# COFFS HARBOUR CITY COUNCIL

Our ref: 2737356 (DA 700/11)

**MP 08-0080, Residential Subdivision  
Lot 112, DP 1073791, Lyons Road, North Bonville**

Council refers to the above Major Project Application and to the Departments request for comment on the Environmental Assessment.

ROAD PROFILE 9 FIRE TRAIL

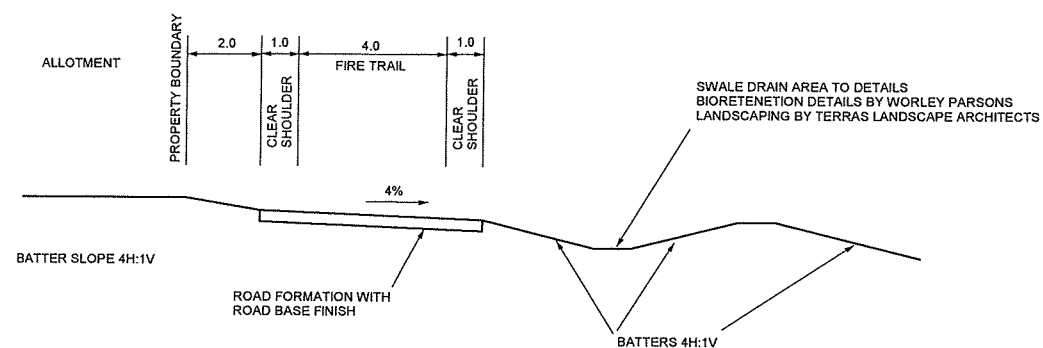
The subdivision should comprise perimeter roads to interface with bushland and open space areas. On this aspect the north eastern section of the subdivision (Stage 5 in the concept staging plan) should be amended to delete the cul-de-sac and replace the proposed perimeter fire trail with a perimeter public road. This arrangement will likely increase the residential footprint, provide better surveillance of natural bushland areas and support an improved urban design outcome for the development.

LEGEND SEWER

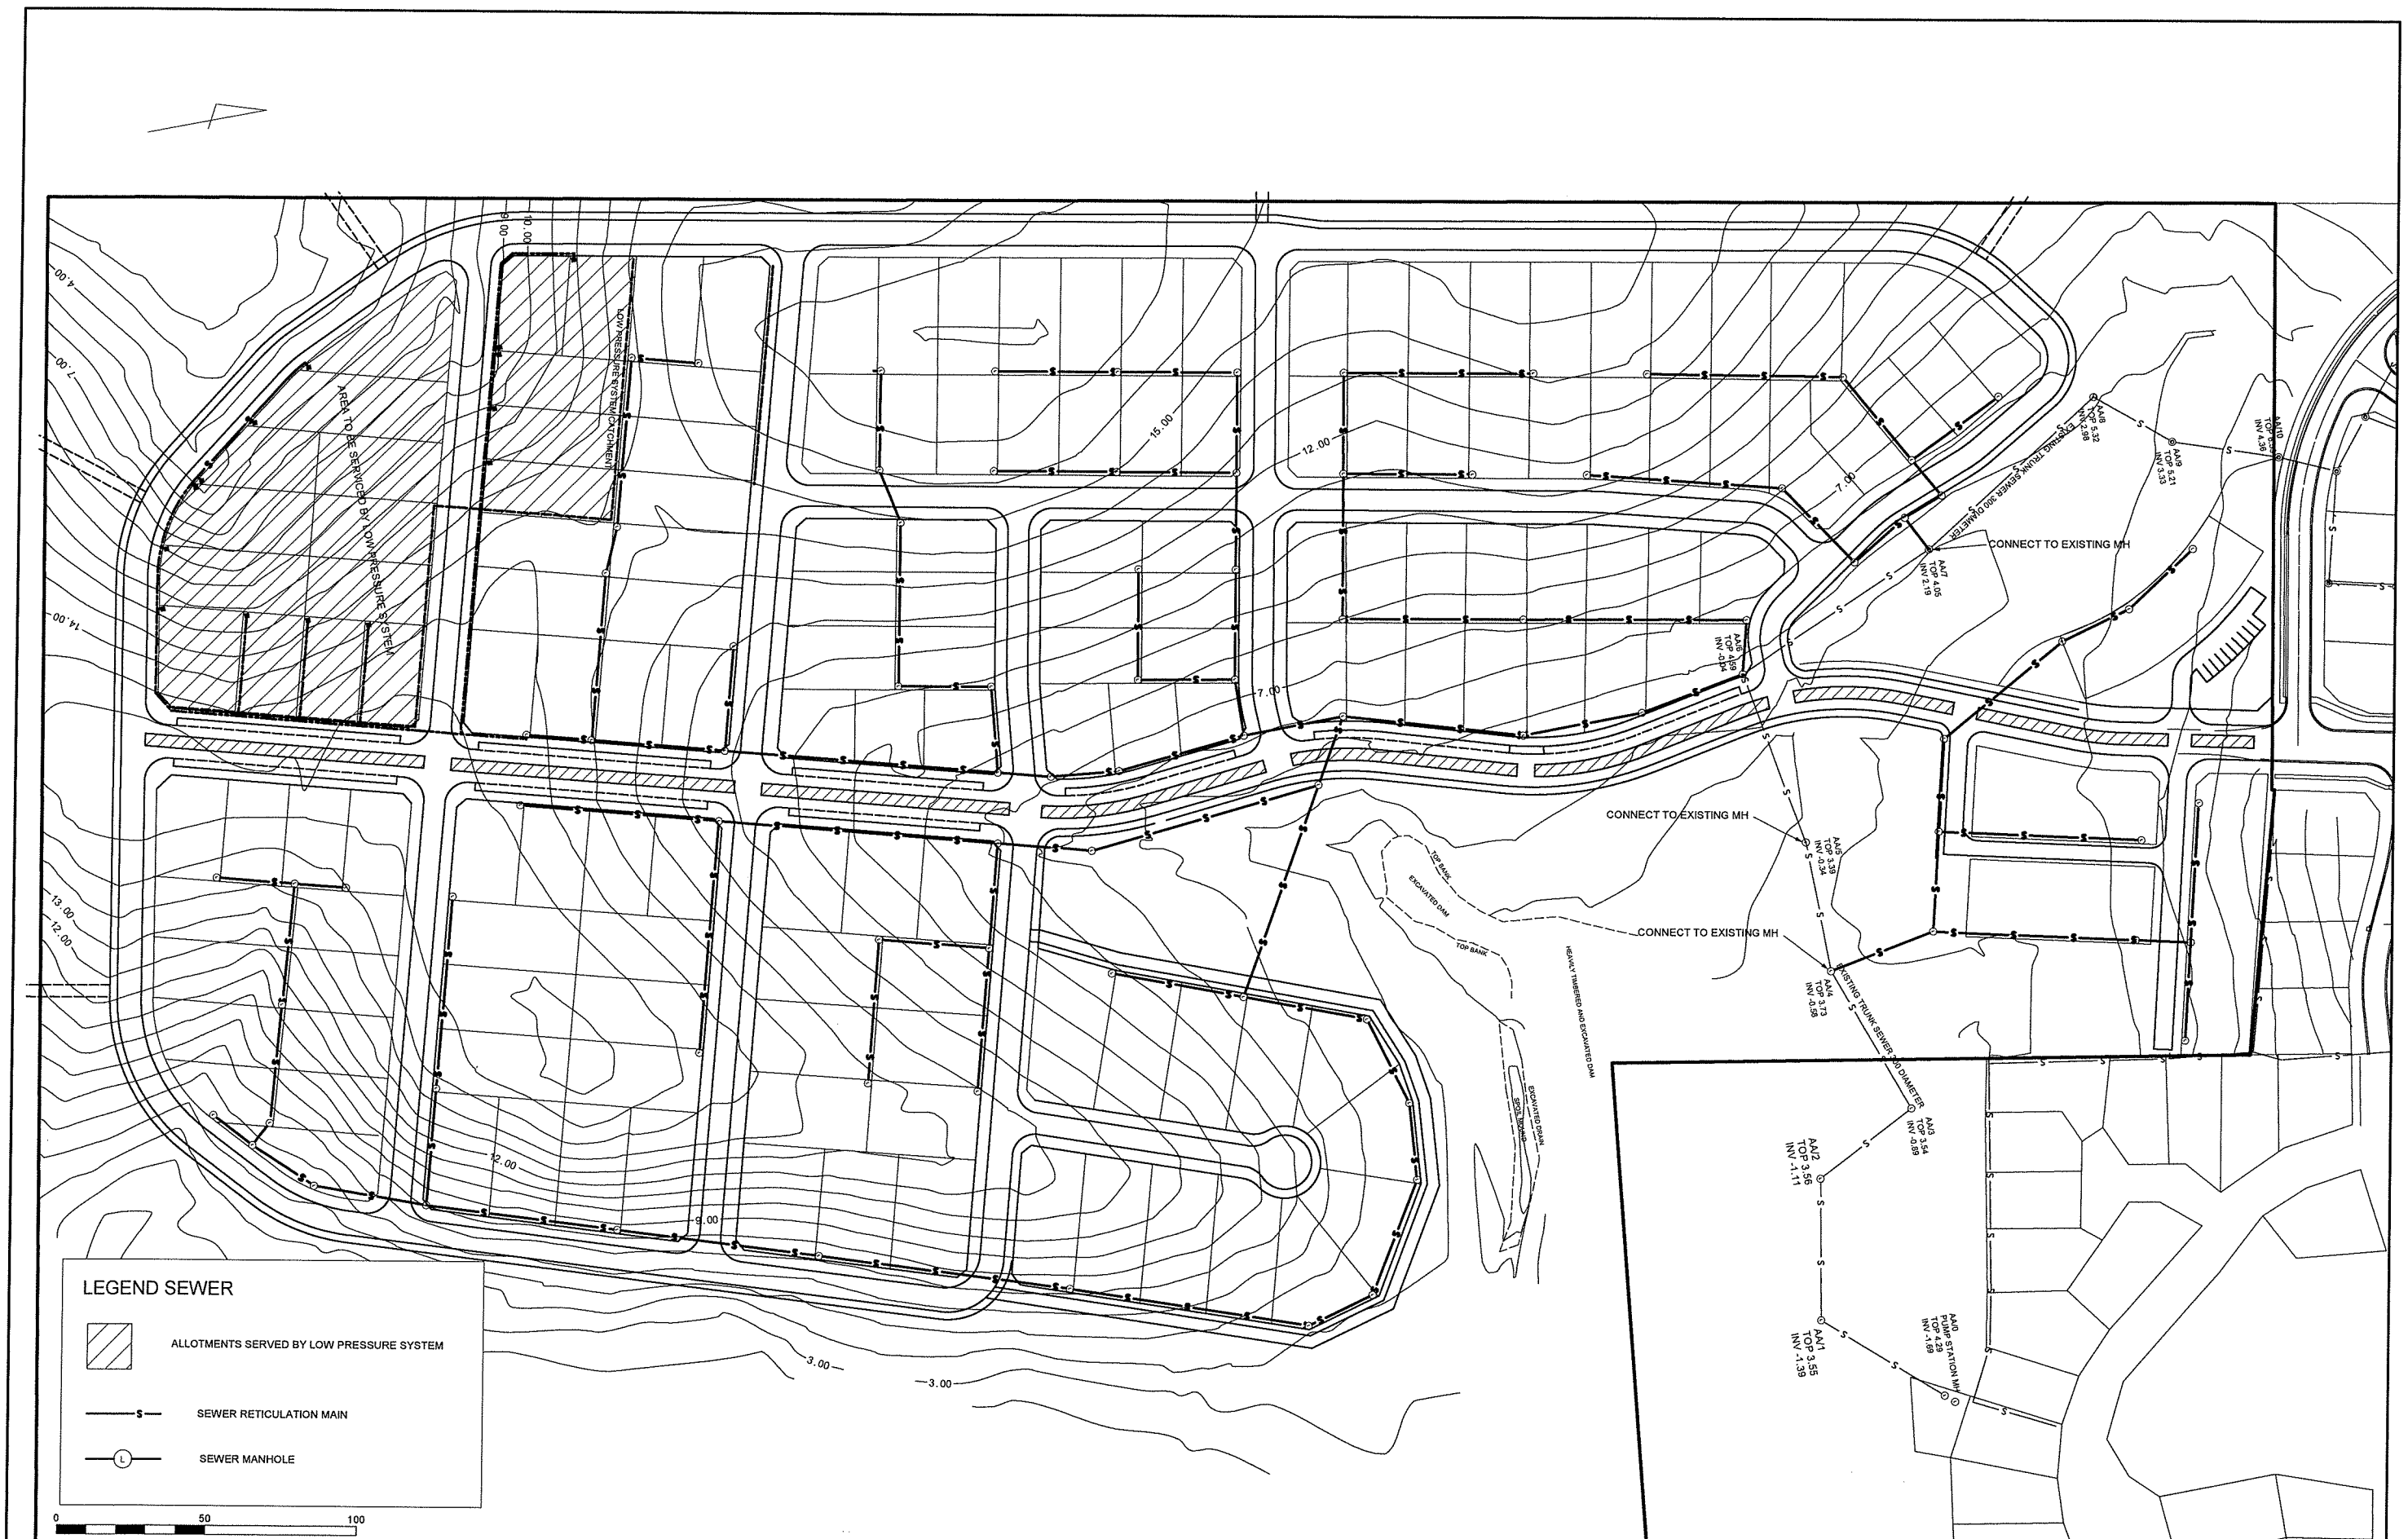
The Project Application seeks approval for the installation of *"a low pressure system which utilises a small household pump at (17) lots and a common rising main to a discharge manhole"*. These systems are not permissible under Coffs Water's Sewerage Strategy. An additional sewer pumping station is required for servicing the 17 lots.
